# DRAINAGE LETTER

**5819 PALMER PARK BLVD.**  
PART OF LOT 1, POWERS CENTER, FILING NO. 3

SUBJECT: Drainage Letter  
5810 Palmer Park Blvd.

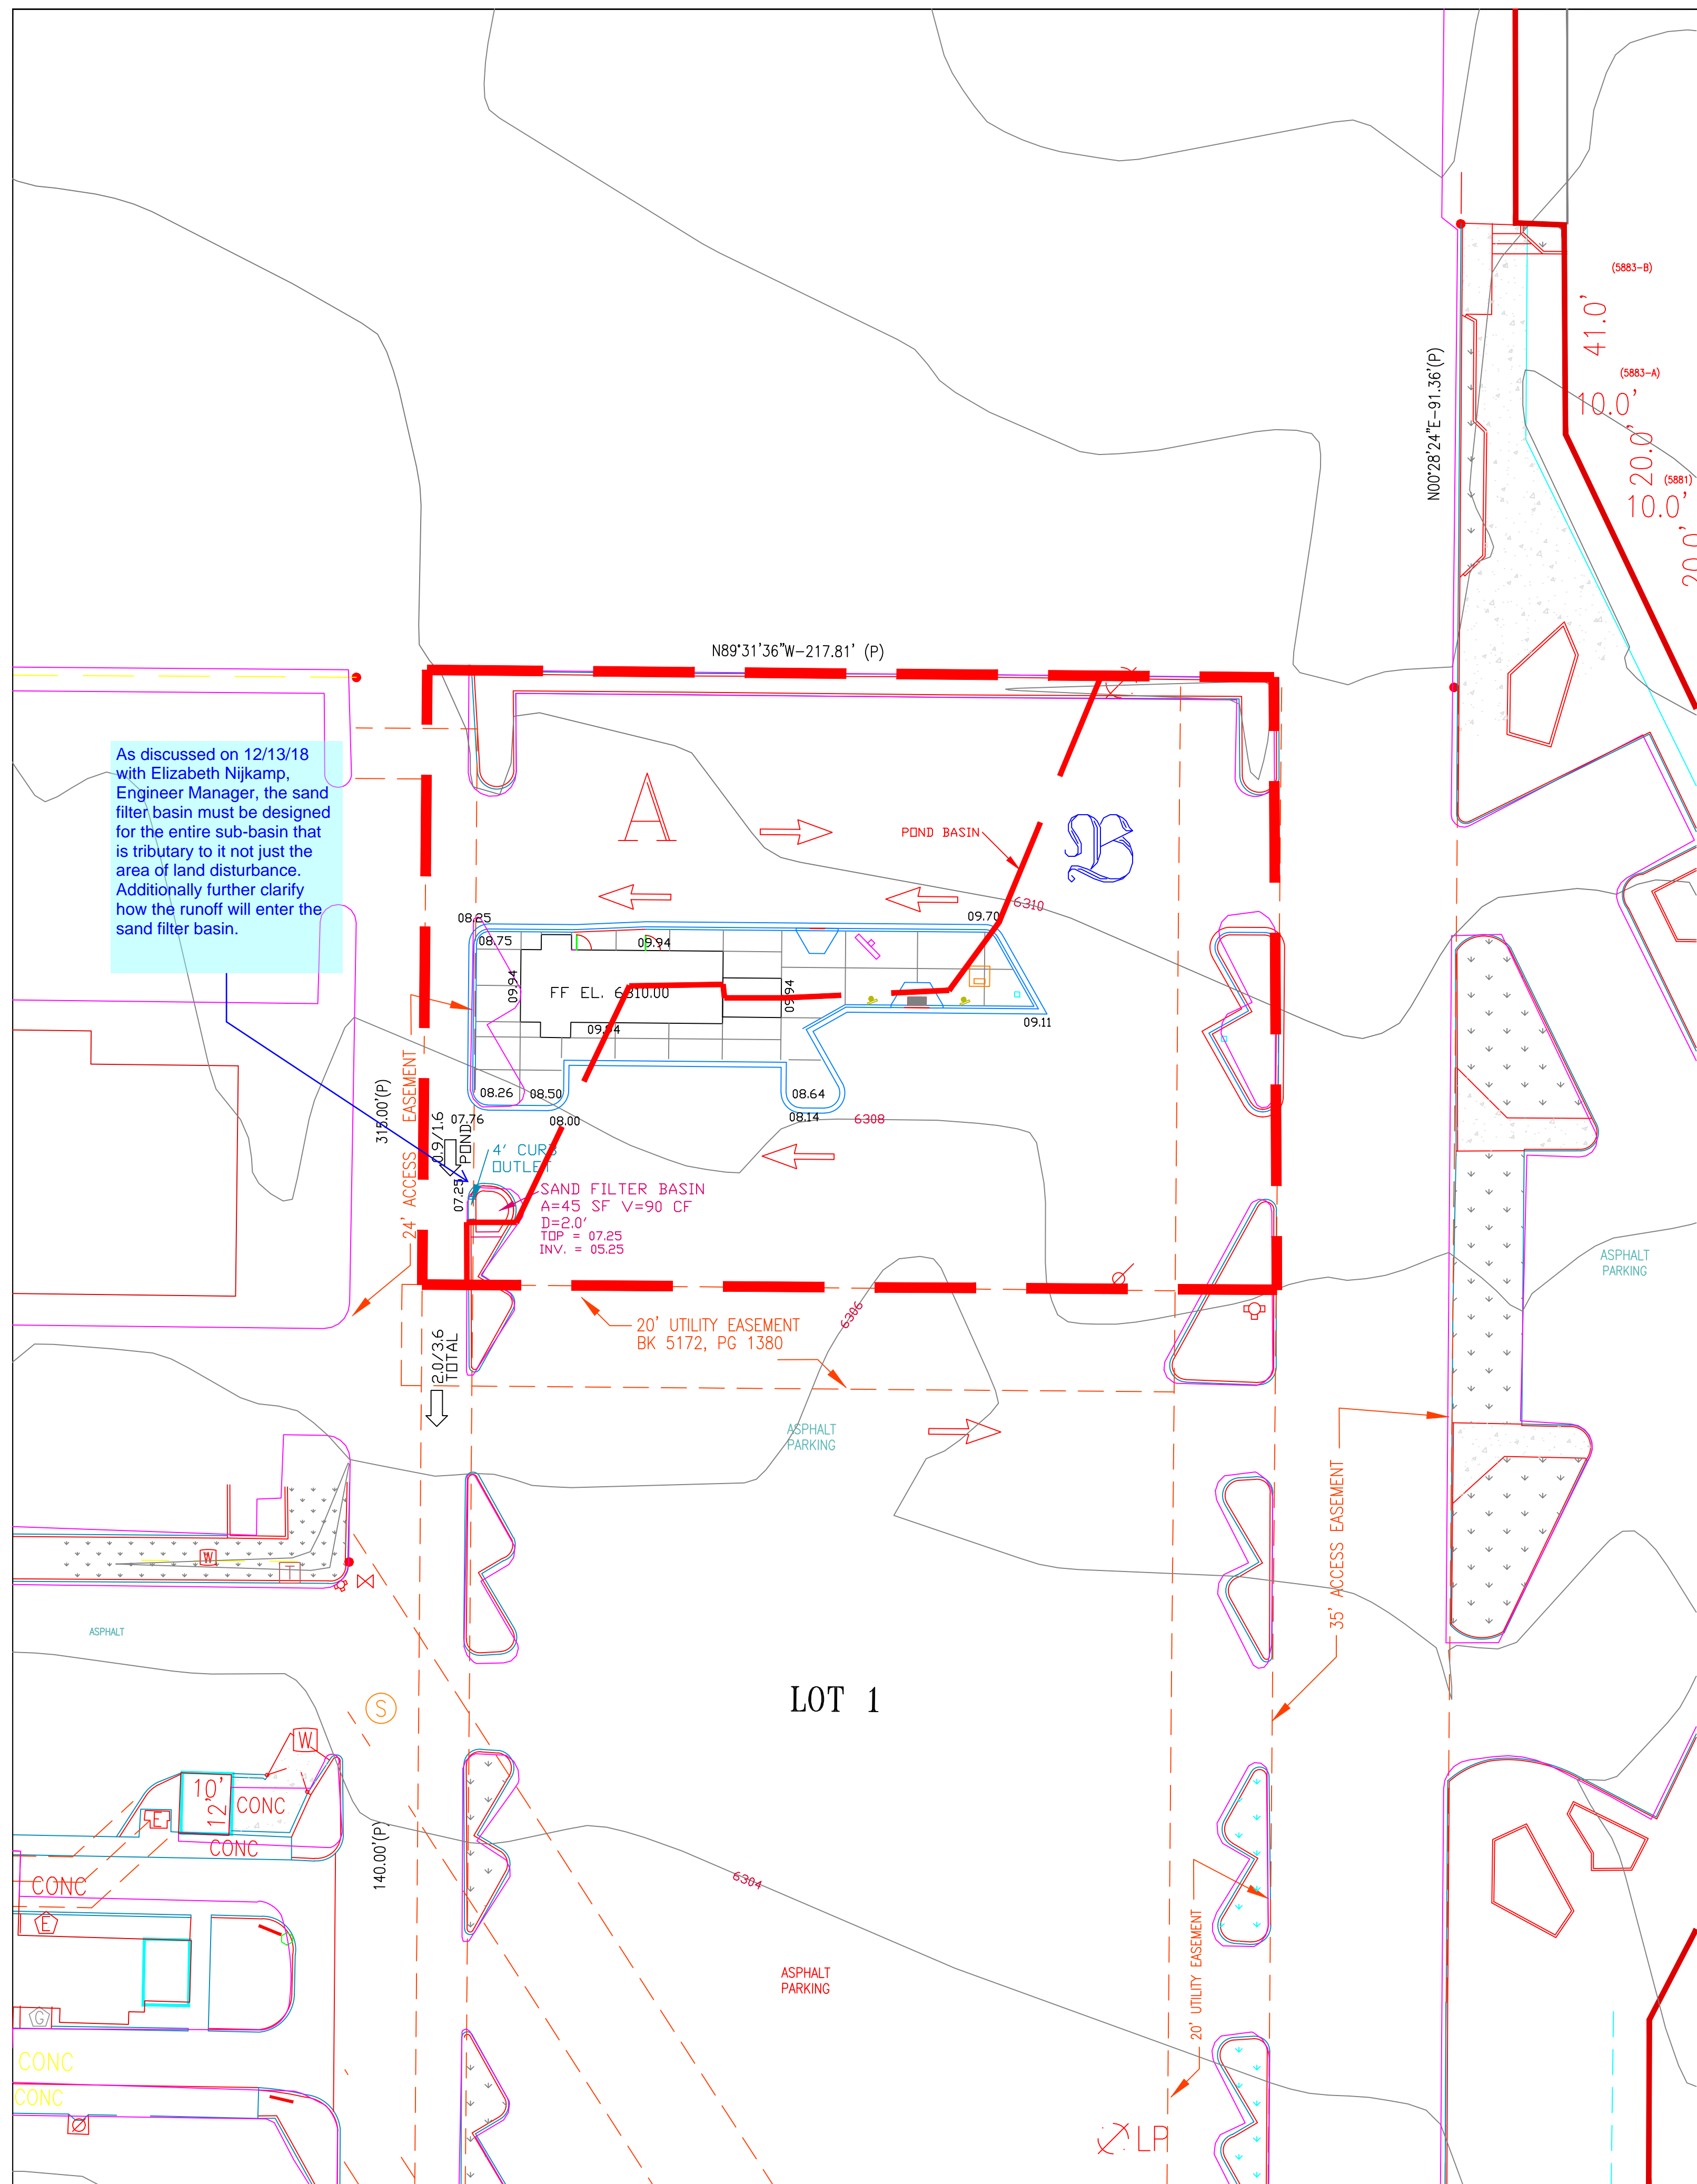
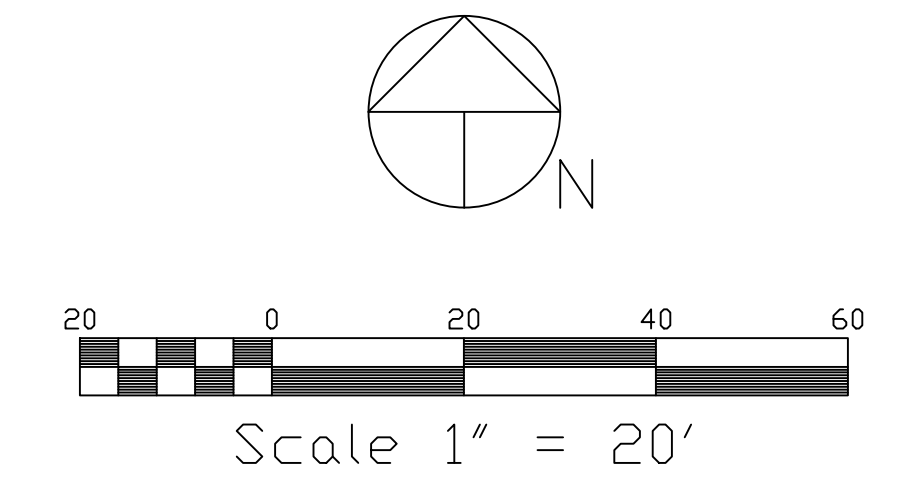
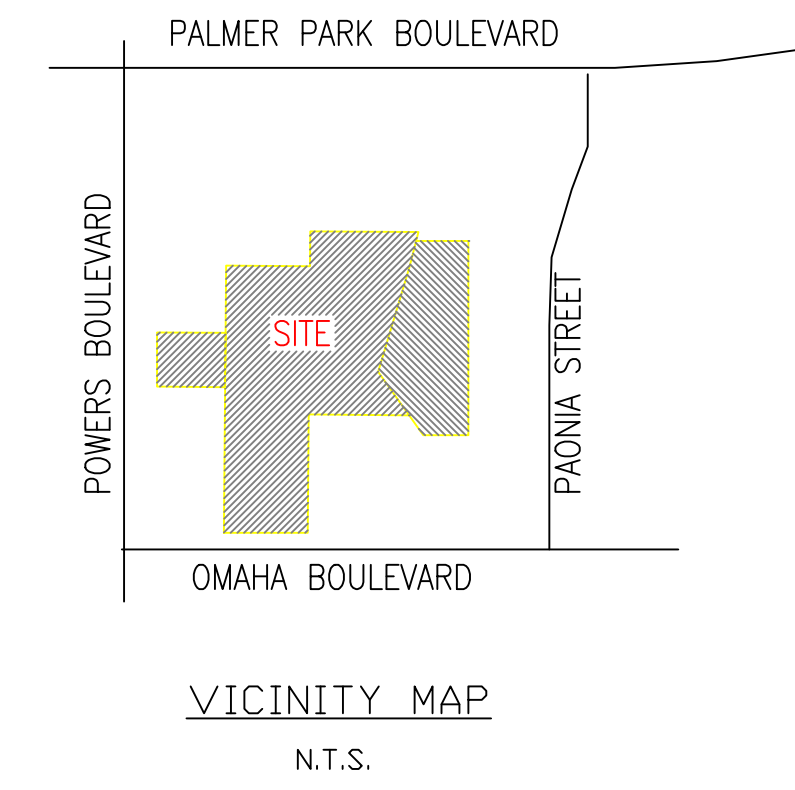
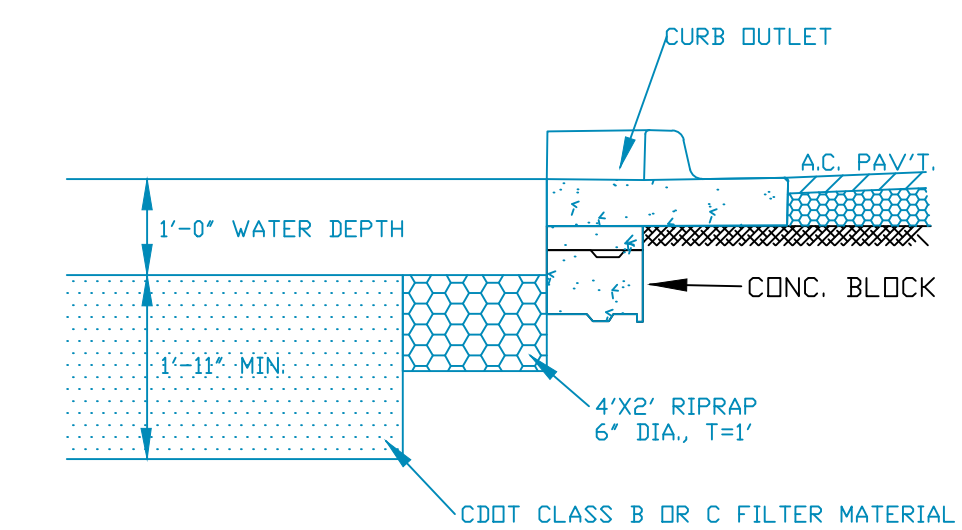
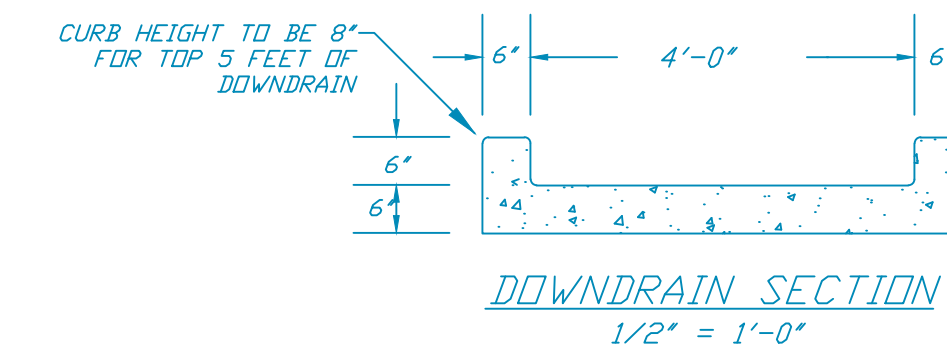
Based on the contours shown and the location of the curb opening it does not appear that much of the runoff will enter the sand filter basin. Show the sub-basin that is tributary to the sand filter.
